Application no: H02/0812/01

Description: Refurbishment of 7-11 and new  
house and bungalow with  
garages at rear

Location: 7-11 East Street  
Crowland

Amendment: Changes to bungalow roof  
dwg no. CRO 002 rev 21 Aug 01

SCALES 1 / 100
DRG. NO. GRO 002 DATE JUNE 01

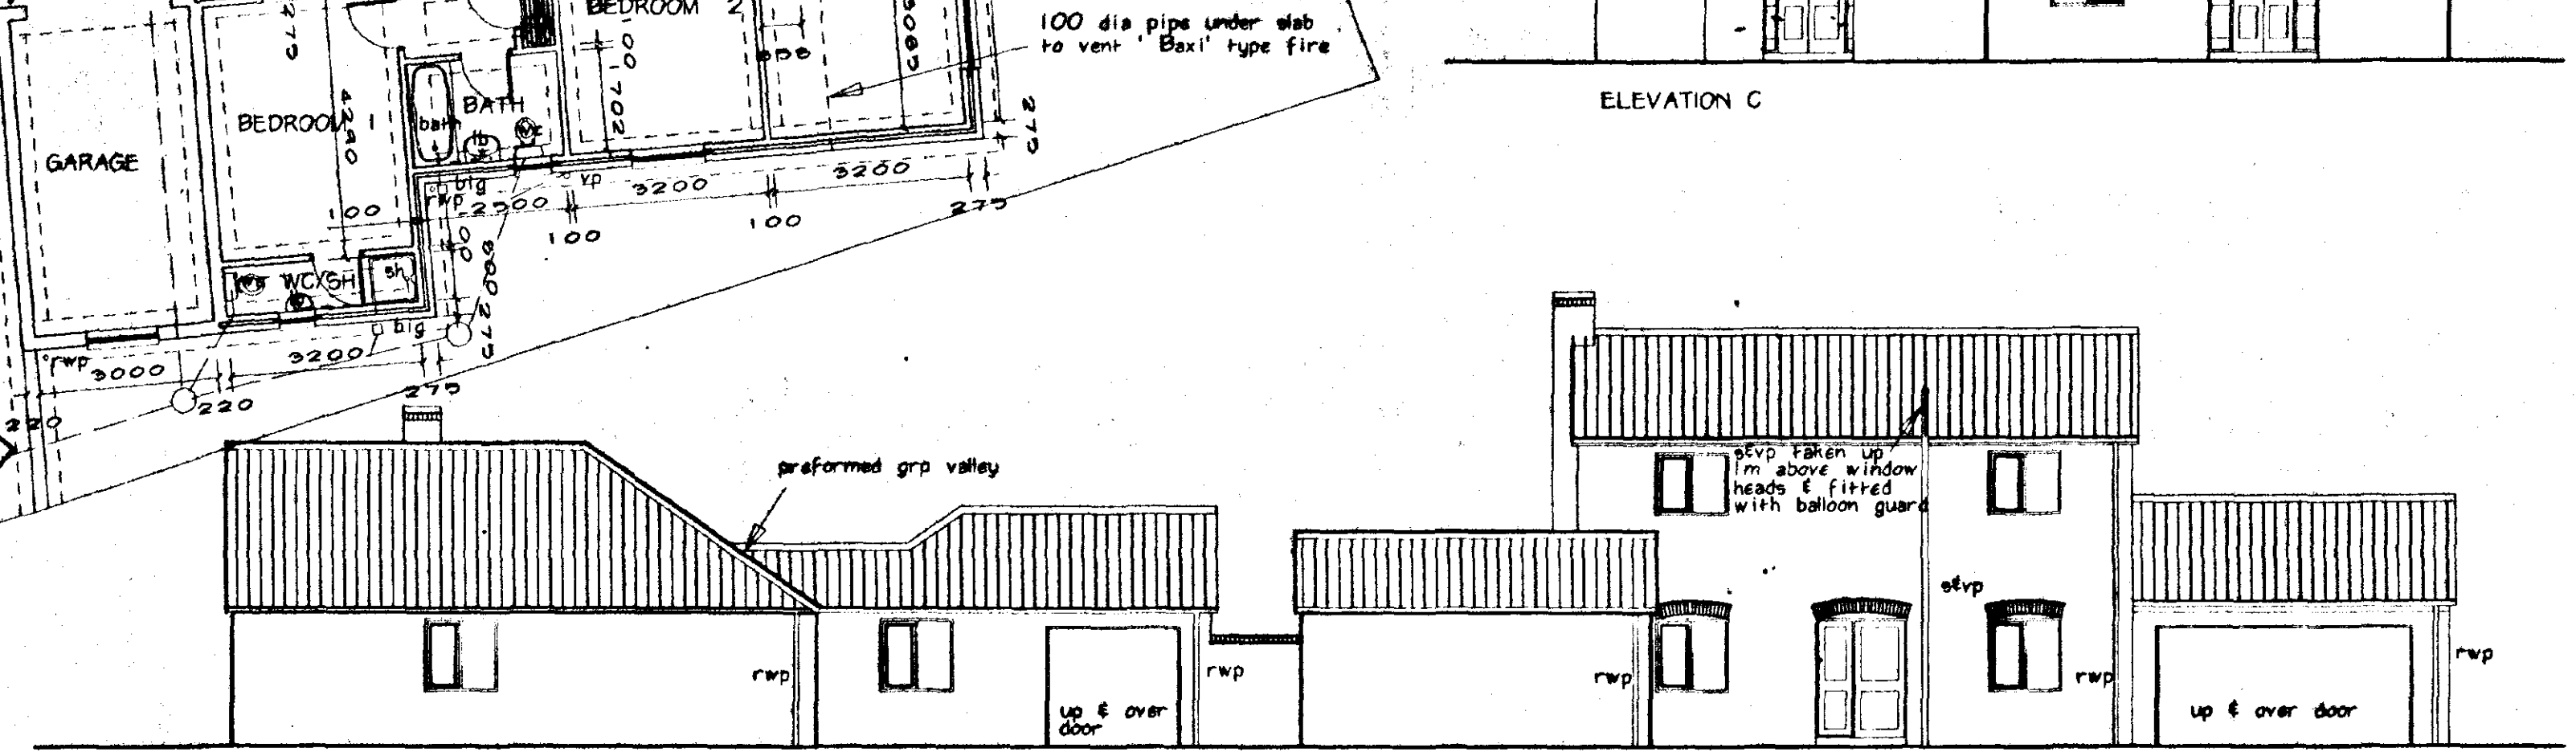
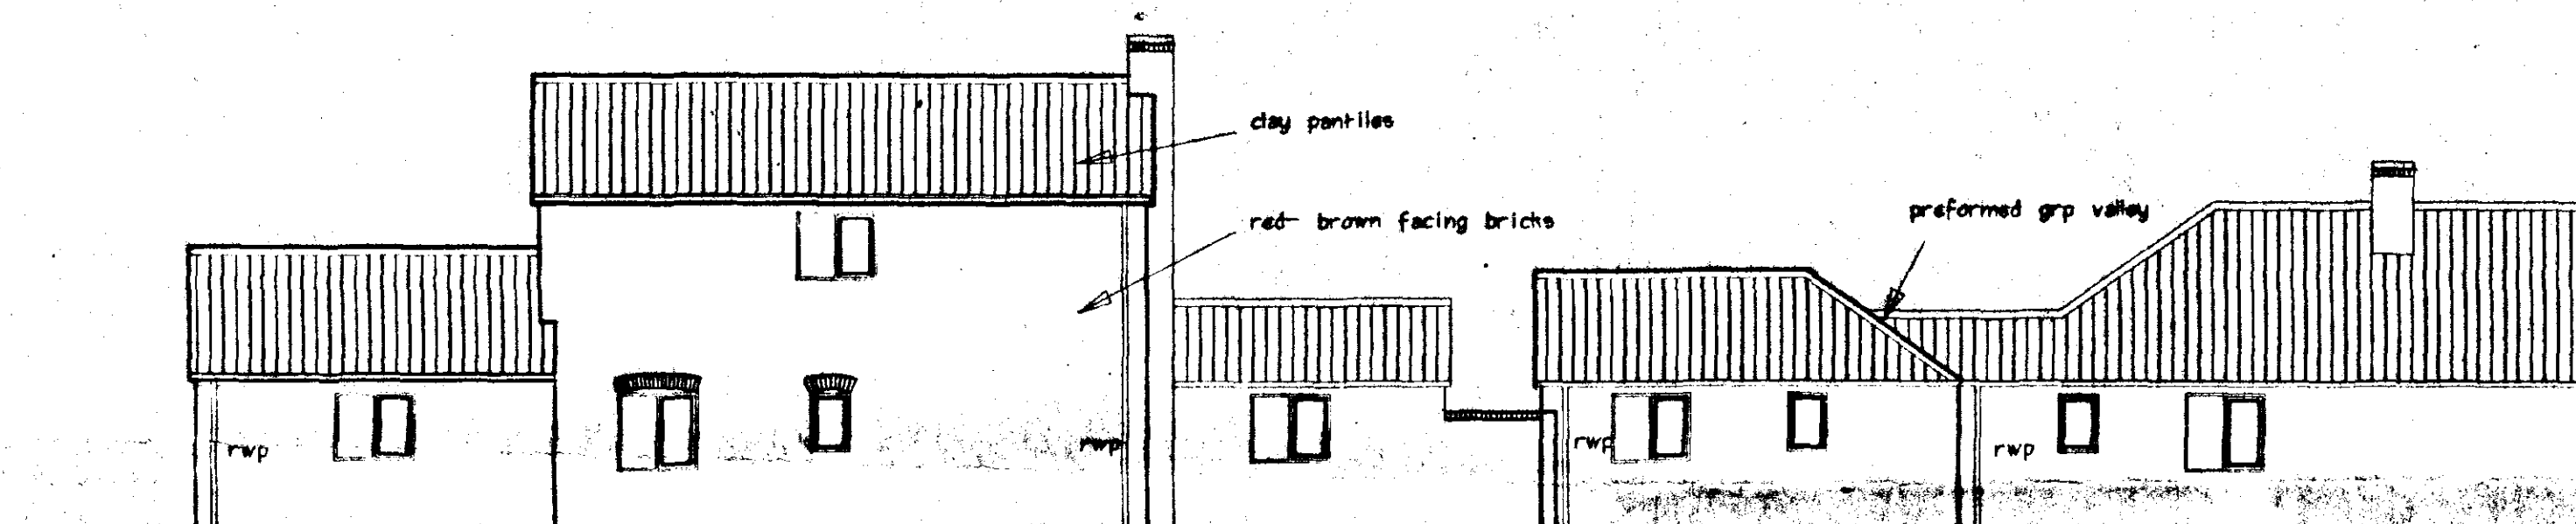
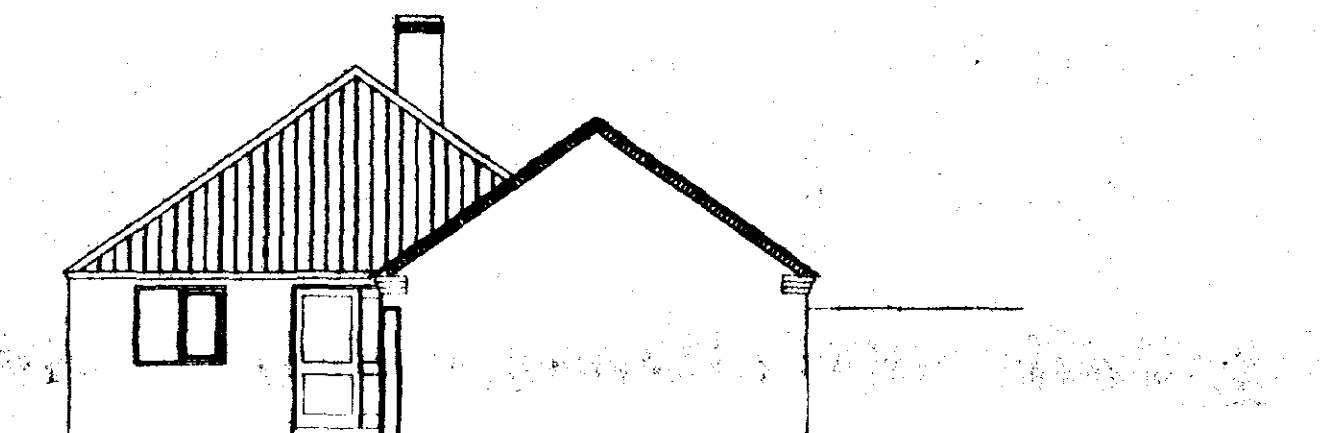
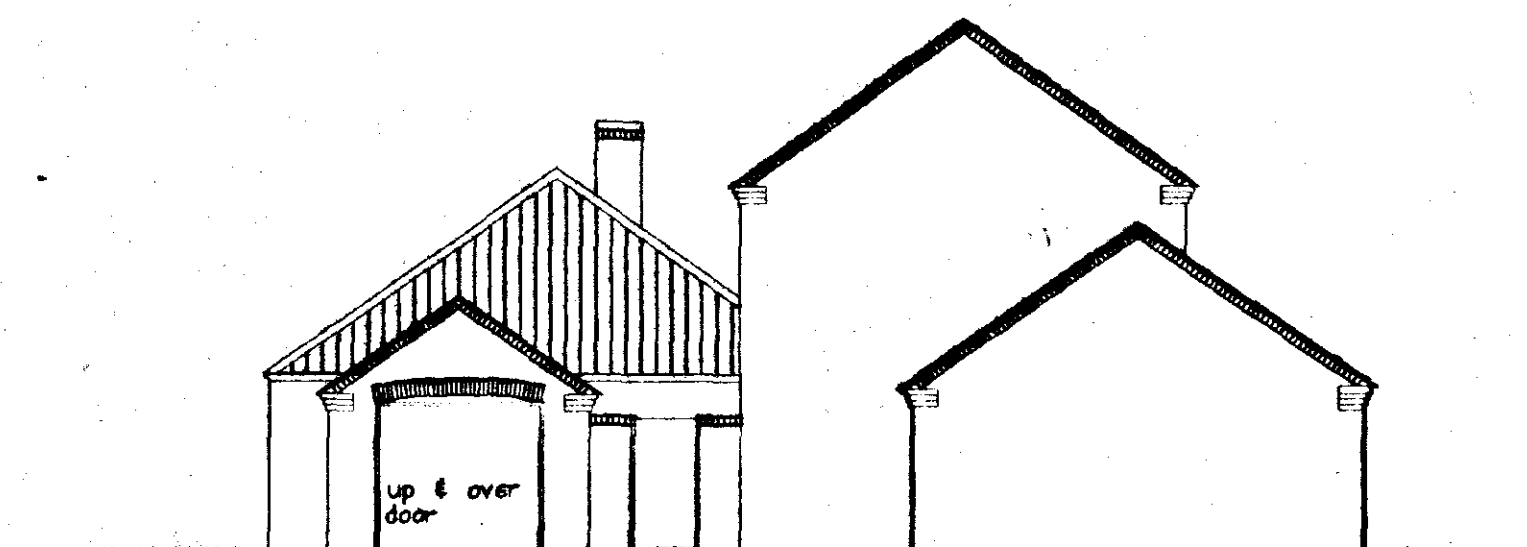
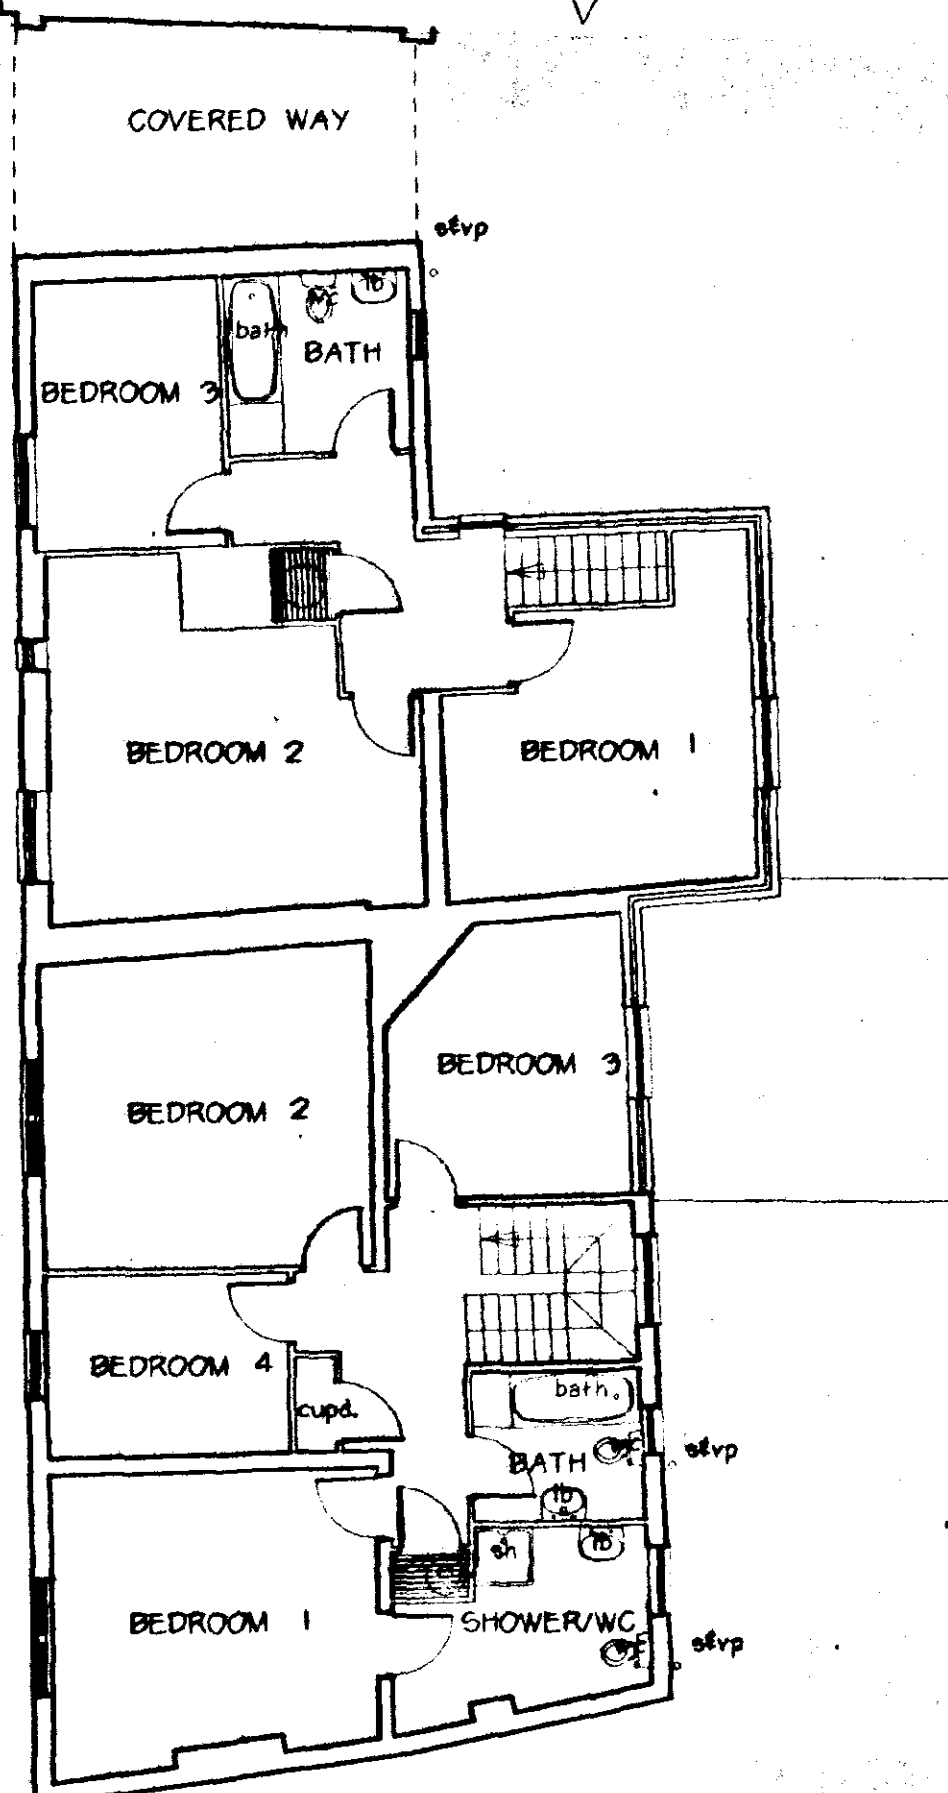
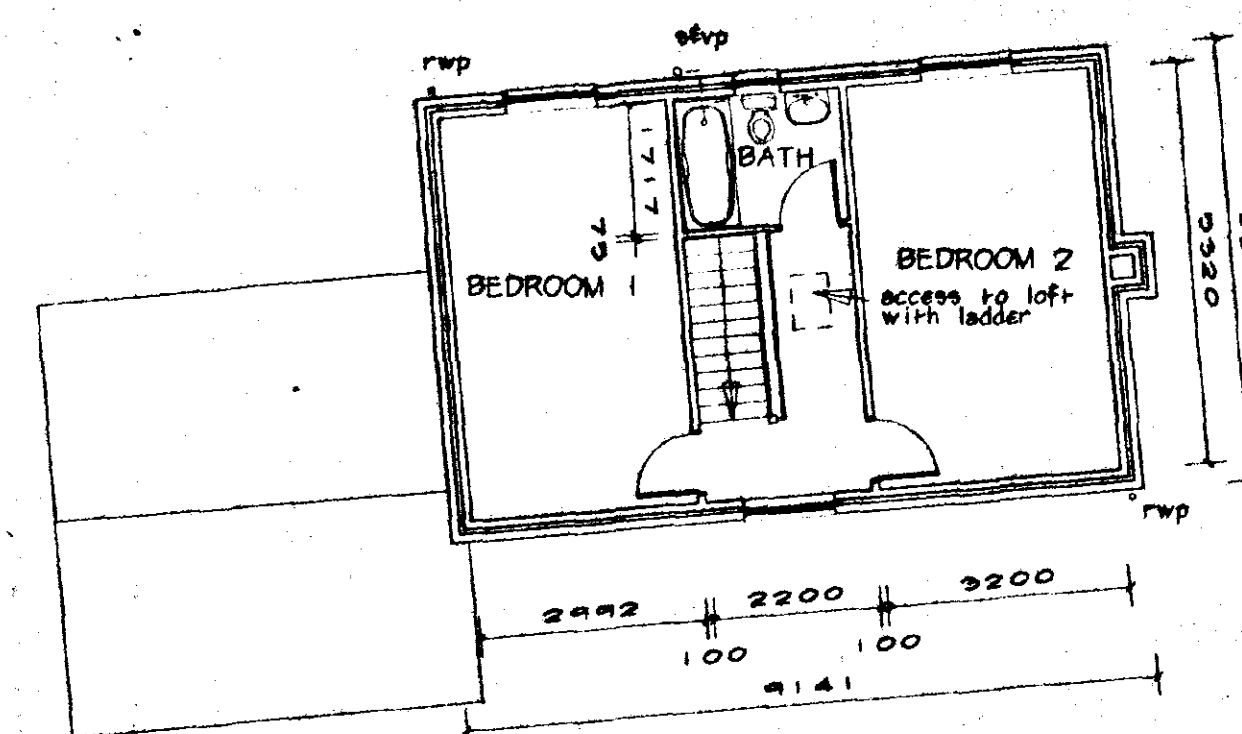
Amendment: Revisions to elevations  
Dwg. no. CRO 002

Following our discussion at the planning office on Tuesday last we have modified the drawings of the proposed new dwellings at the rear of 7-11 East Street in accordance with your suggestions and removed the soldier courses from the elevations substituting relieving arches above openings where possible.
